From: Peter Cleveland
Sent: 05 September 2012 16:29
To: 'David Bennett'
Subject: FW: 3 Mount Pleasant Arundel AB/62/12/L
Attachments: 11245 Revised plans.pdf

From: David Bennett [redacted]
Sent: 20 August 2012 11:00
To: peter.cleveland@arun.gov.uk
Cc: Ian Wightman
Subject: 3 Mount Pleasant Arundel AB/62/12/L

11245 / 06

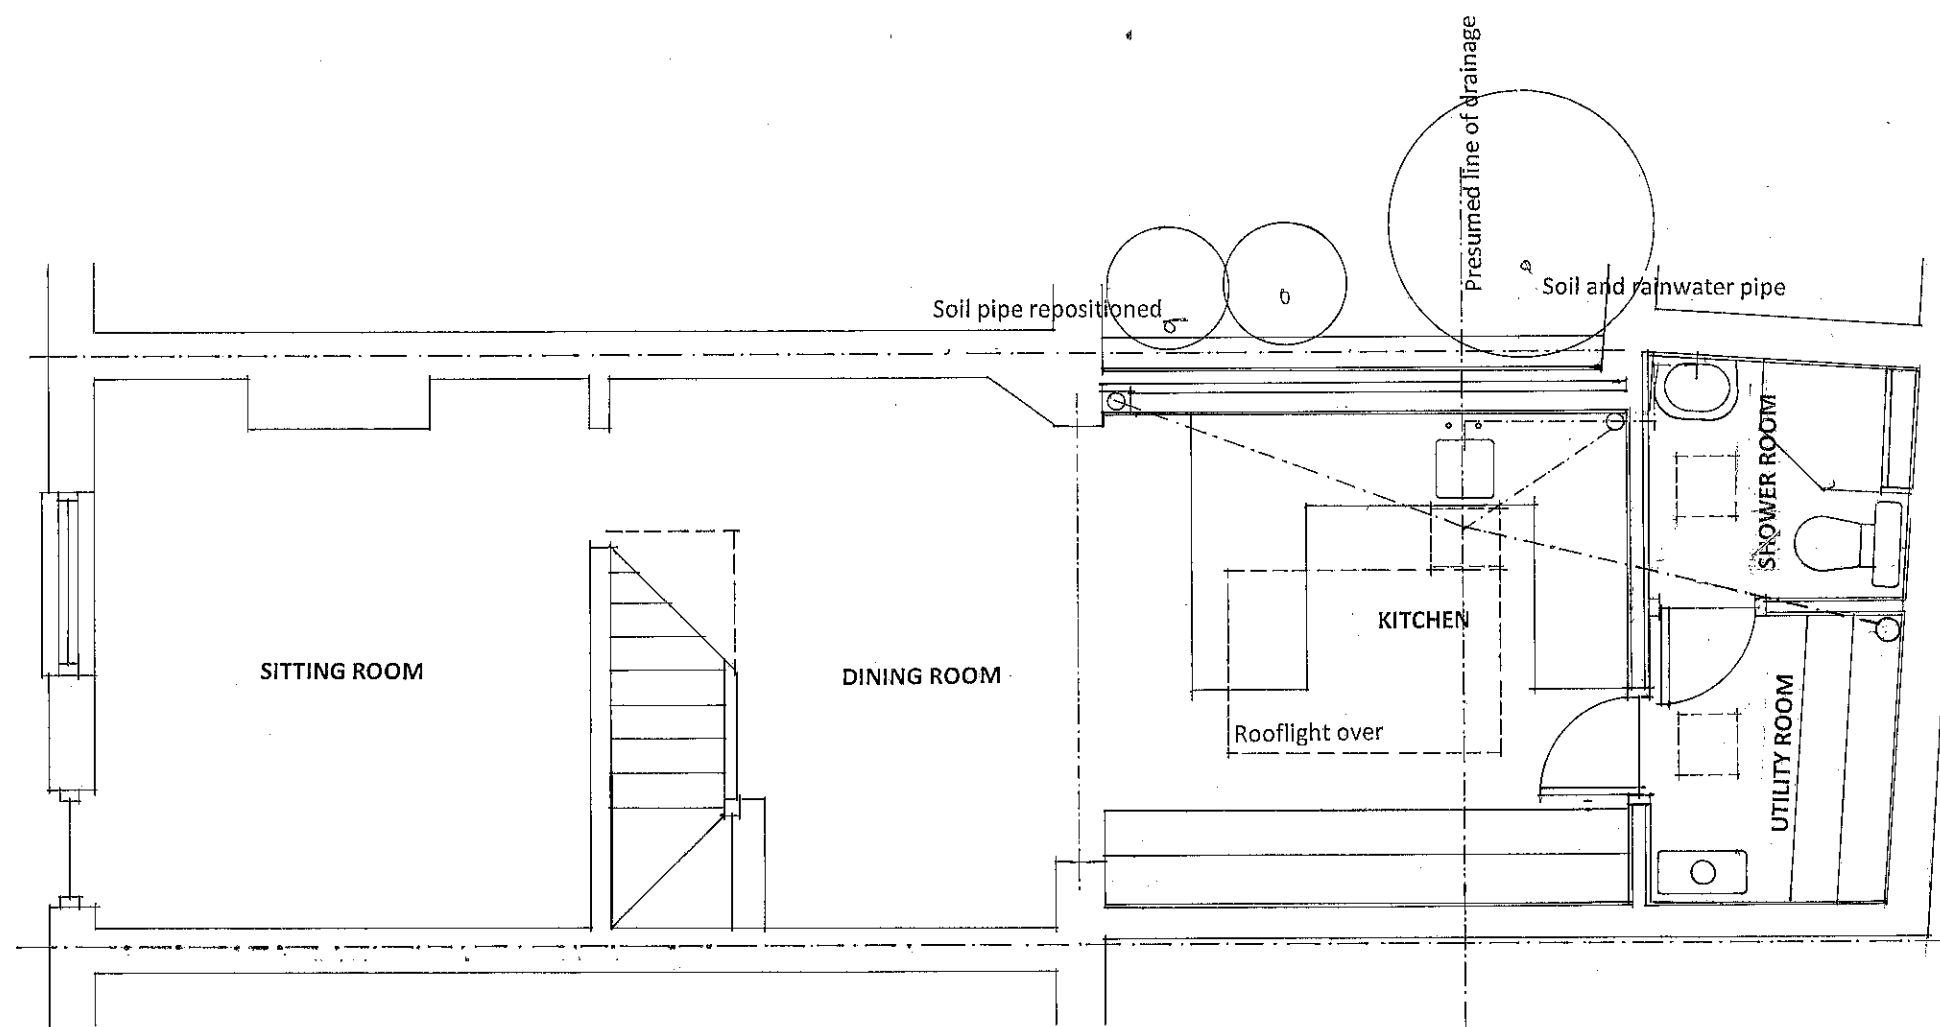
This seems to be an improvement. I think we can probably agree to this if the fabric being removed is not historic.

As discussed last week, I attach revised plans of the above. By comparison to the original proposal, this scheme removes only the pier between the existing door opening and window opening, and the small section of wall below the window, all of which was rebuilt when the present kitchen extension was built.
